Development Control
Ribbles Valley Borough Council

Your ref: 21.0397
Our ref: D3.21.0397
Date: 14th May 2021

Address: Land at Barrow Brook Enterprise Park, Barrow

Proposal: Proposed new light industrial units/retail trade counter

DRAWING TITLE:  
Existing Site Plan

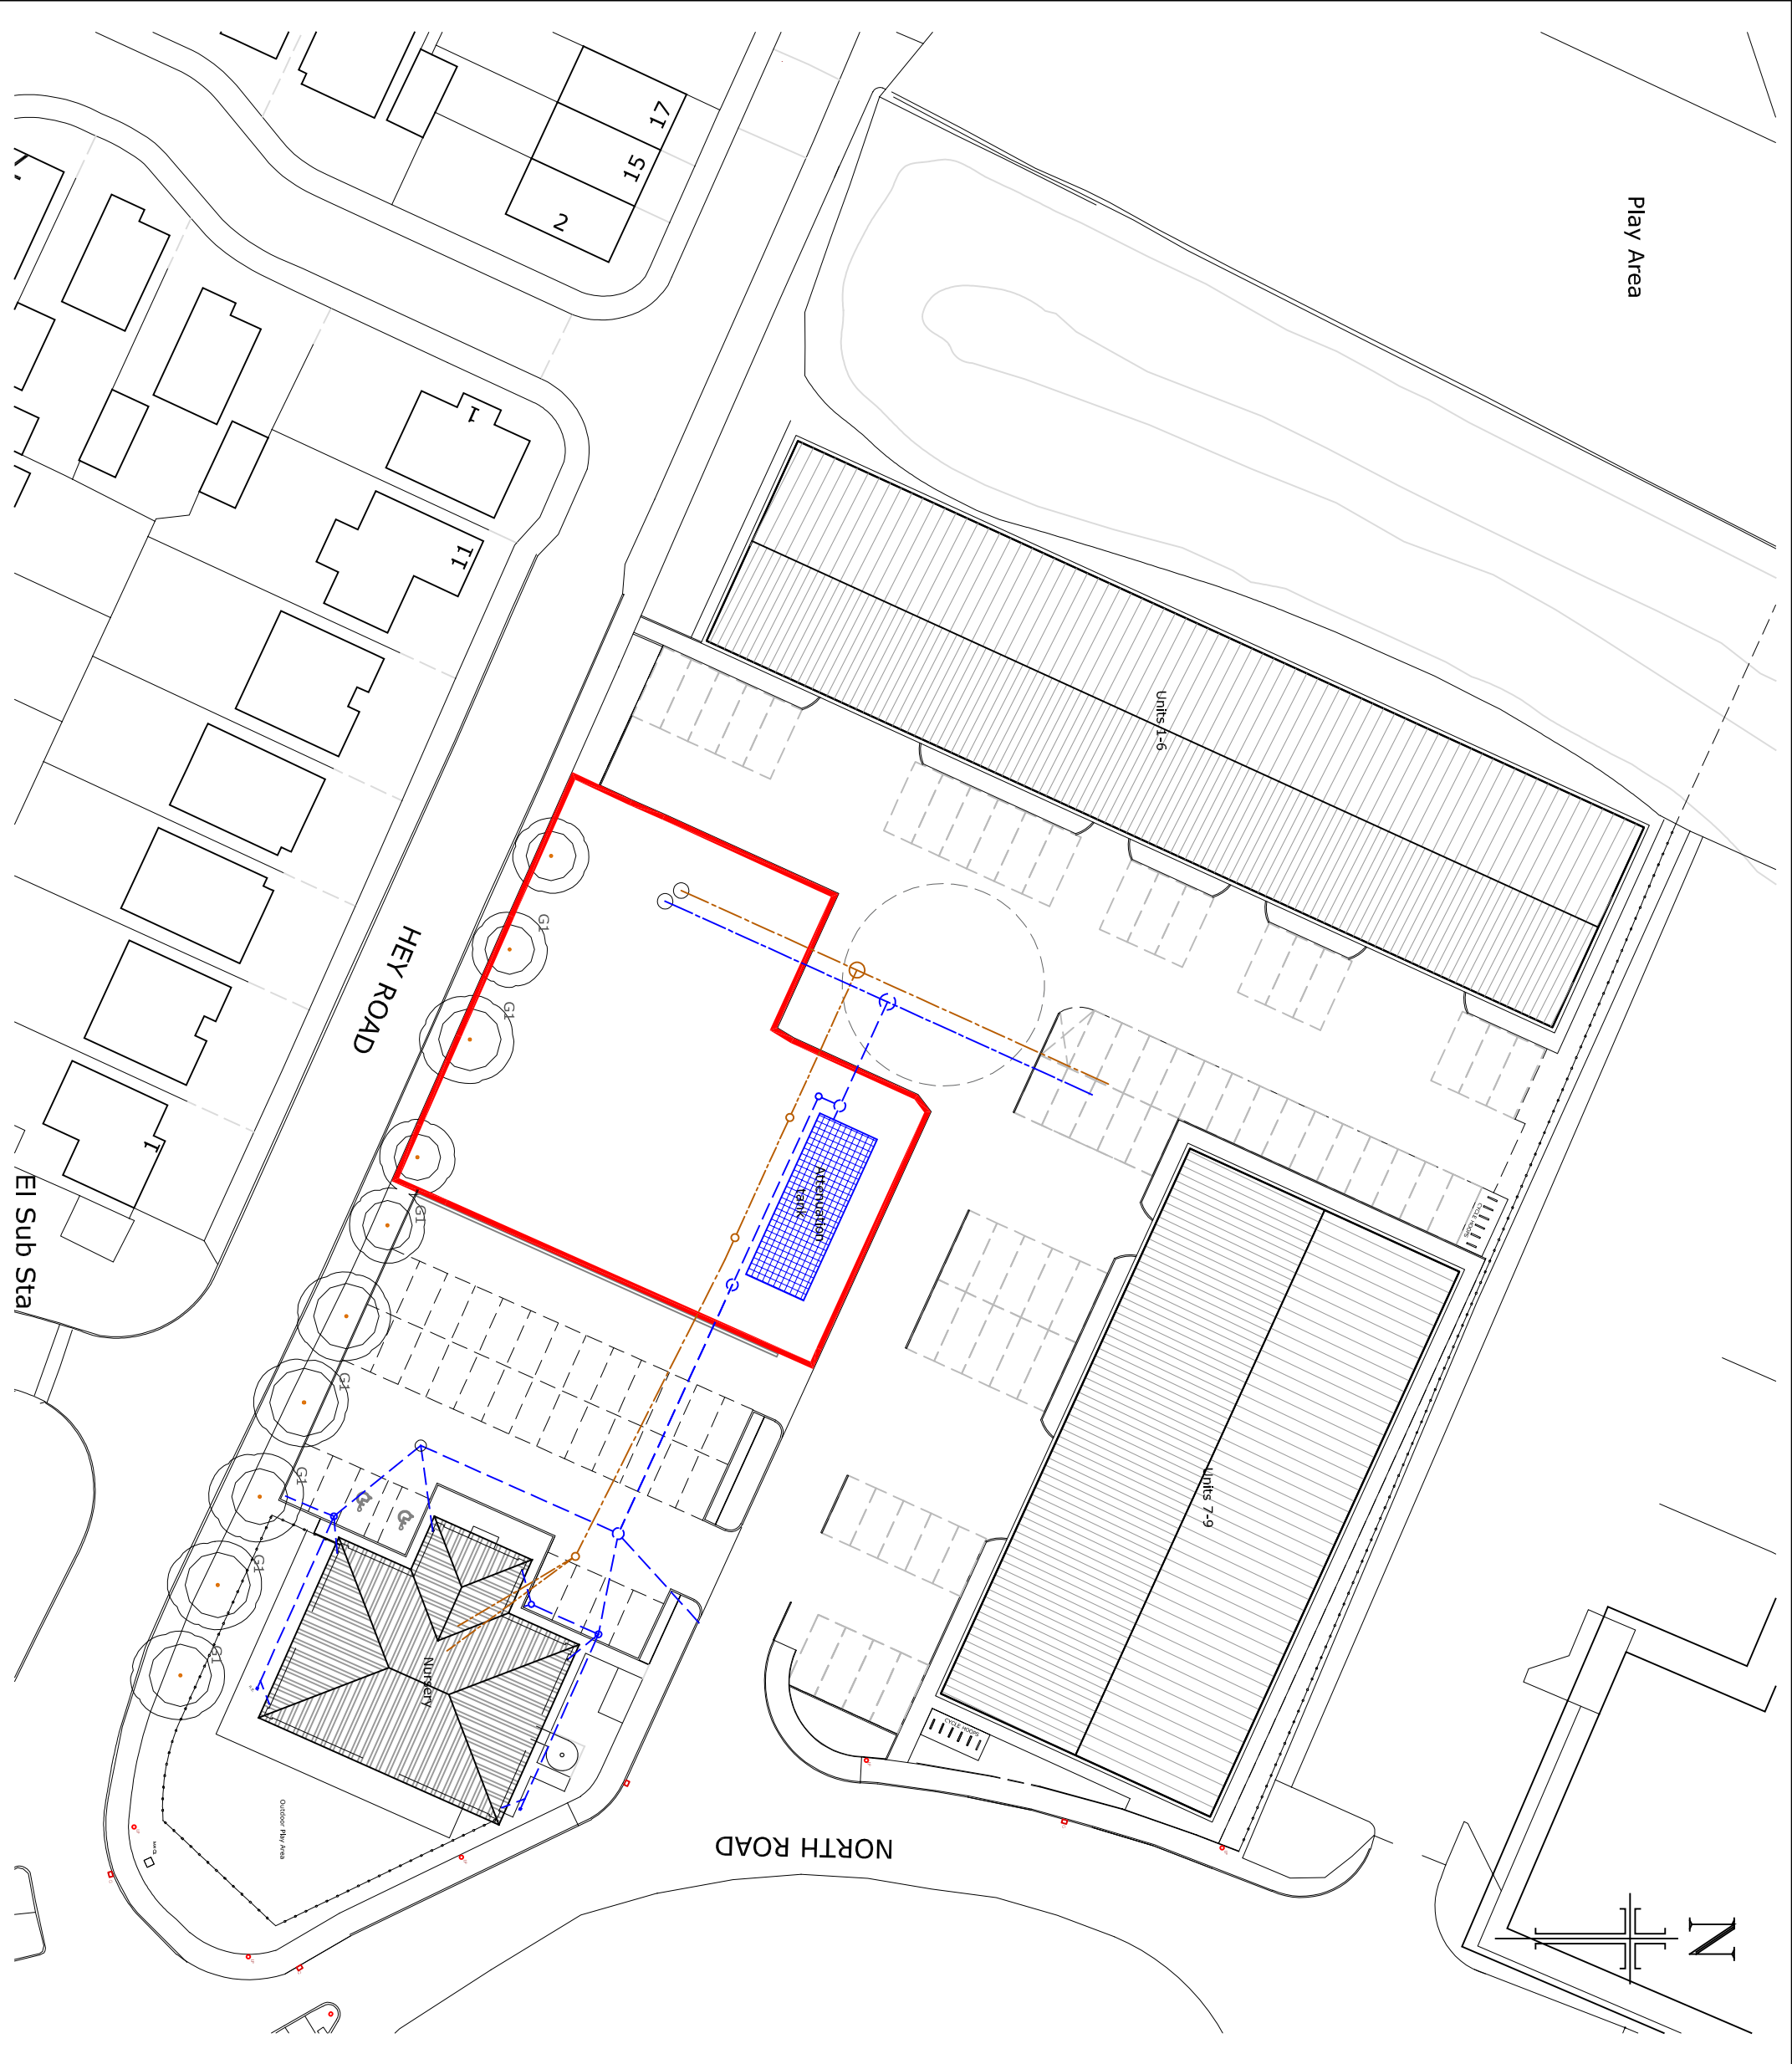
Upon visiting the site I note that the existing car parking layout on site does not match the layout on the site layout drawing. Please amend this as it conflicts with the proposed layout or confirm that the existing layout will be amended.
